Urban Design Observations		Officer:		Stephen Kilmartin	
Description:	Land East of Chipping Lane				
Application Ref:	2016/0193	Case Officer:	S.K	 Ribble Valley Borough Council www.ribblevalley.gov.uk	
Response Ref:	2016/0193/UD/01	Issue Date:	24/03/15

Job	CHIPPING LANE LONGRIDGE		
Title	BOUNDARY TREATMENT DETAILS		
Design By	Date	Drawing Number	Rev
AA	10-02-2016	459/ BTD01	
Drawn By	Scale @ A1		
AA	1:50

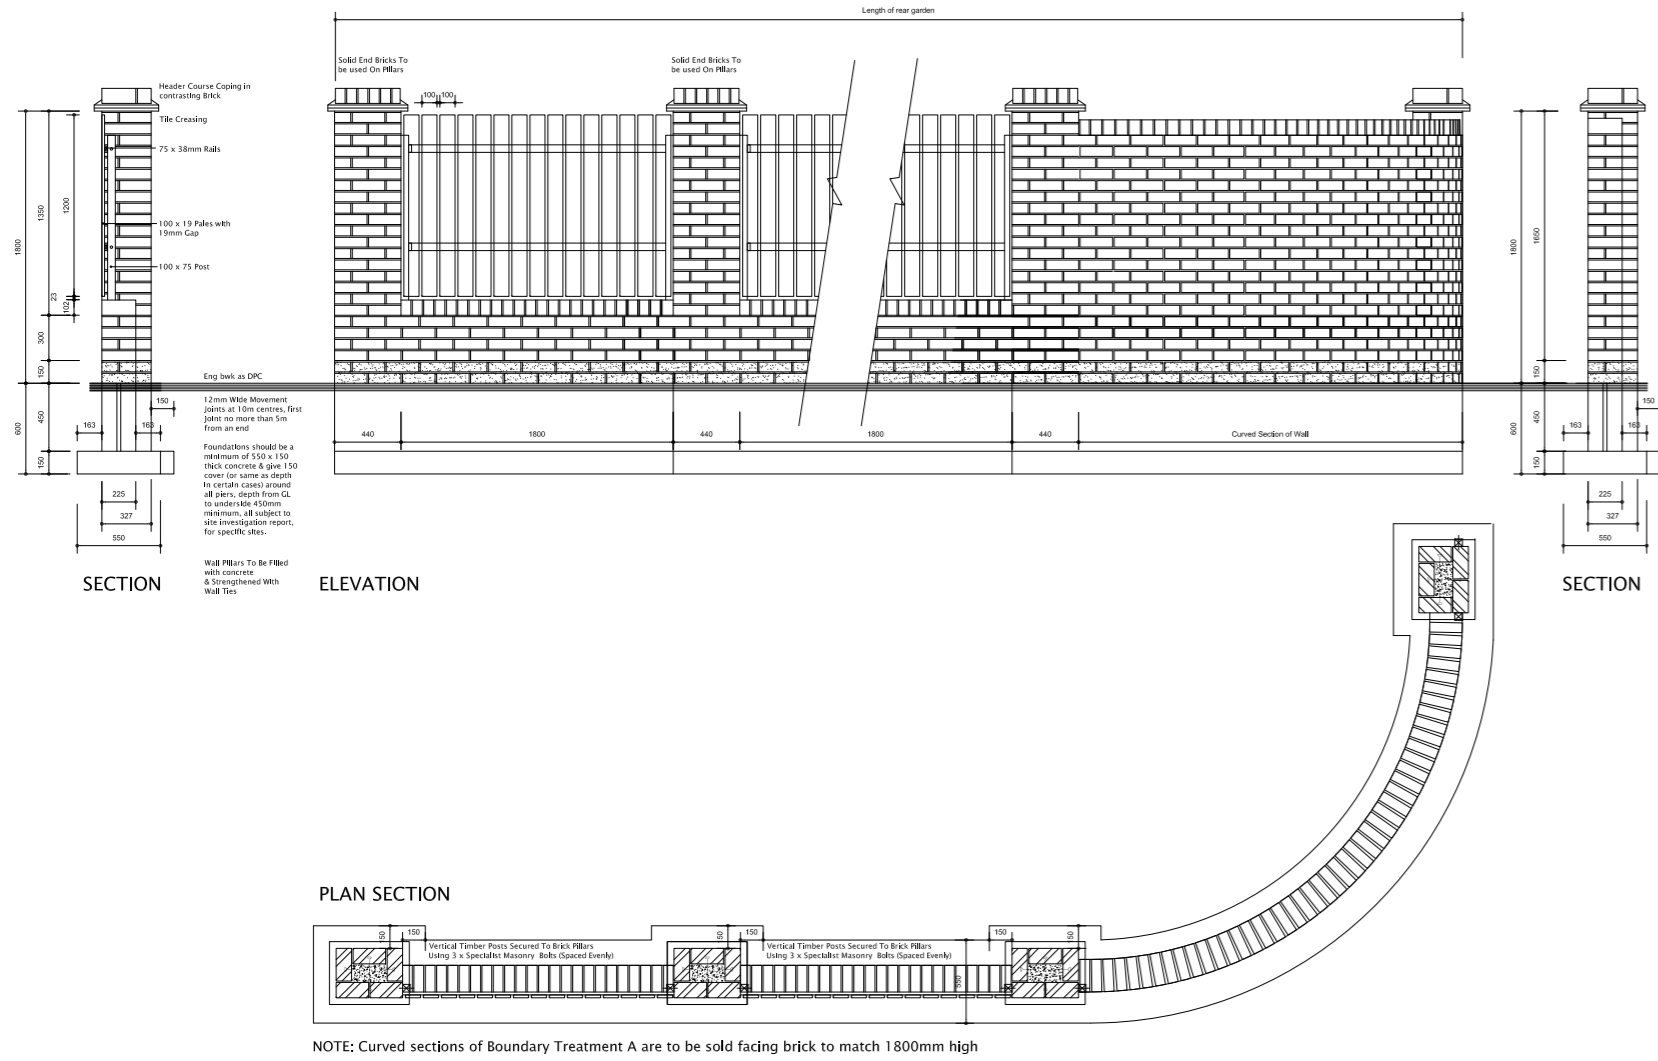
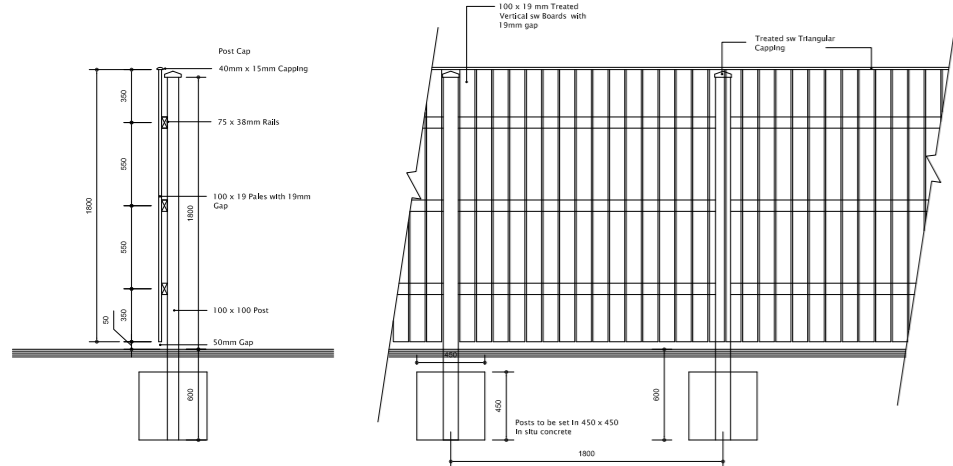
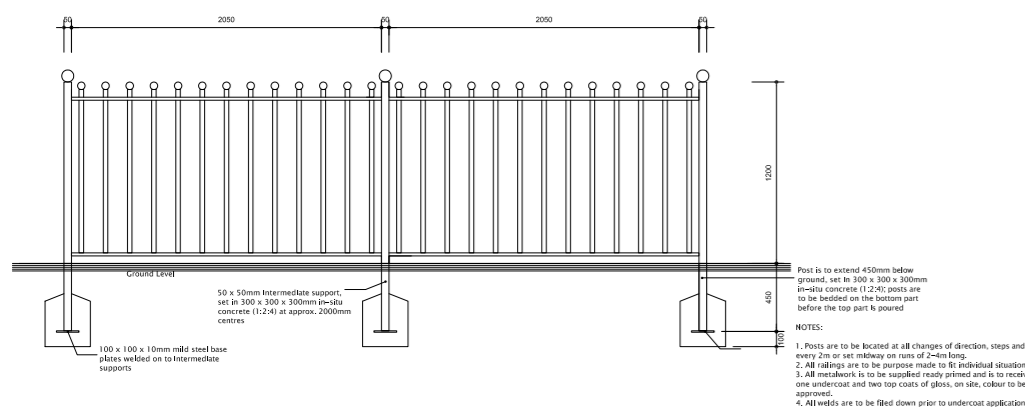
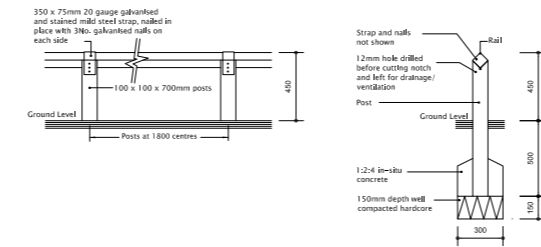
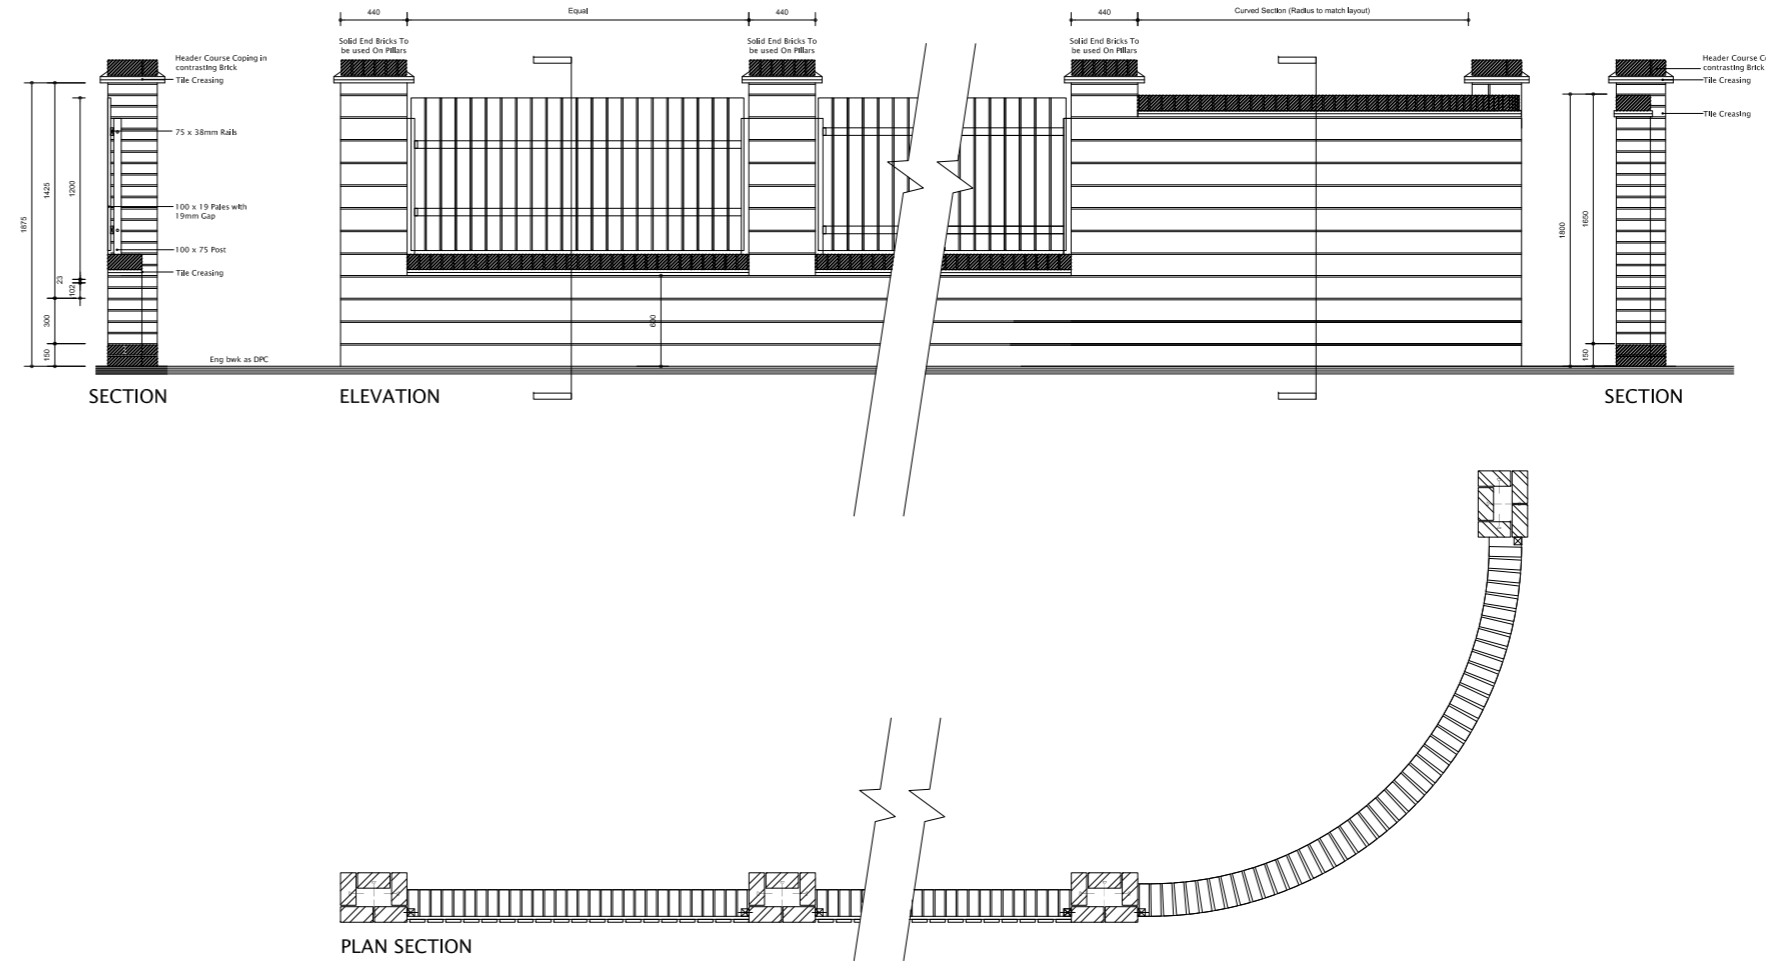
- 2.18** I have noted the introduction of block paved margins which may allow for disabled bays to be accommodated.
- 2.19** Plot 20 (Inglewhite frontage) appears to benefit from a boundary treatment to the frontage and side of the property; I would consider that this would have to be low-level to preserve a sense of openness on this corner.

- 2.21** Noted and agreed, it may be beneficial if the wall benefited from a radius/curve to soften its western corner, I would also suggest the frontage area outside of private residential curtilage be accompanied by a robust landscaping proposal.

- 2.20** (Agent response) This boundary is to be a 750mm high wall to match the material of the surrounding dwellings. The boundary treatment drawing indicates this. Please can you confirm that this is sufficient?
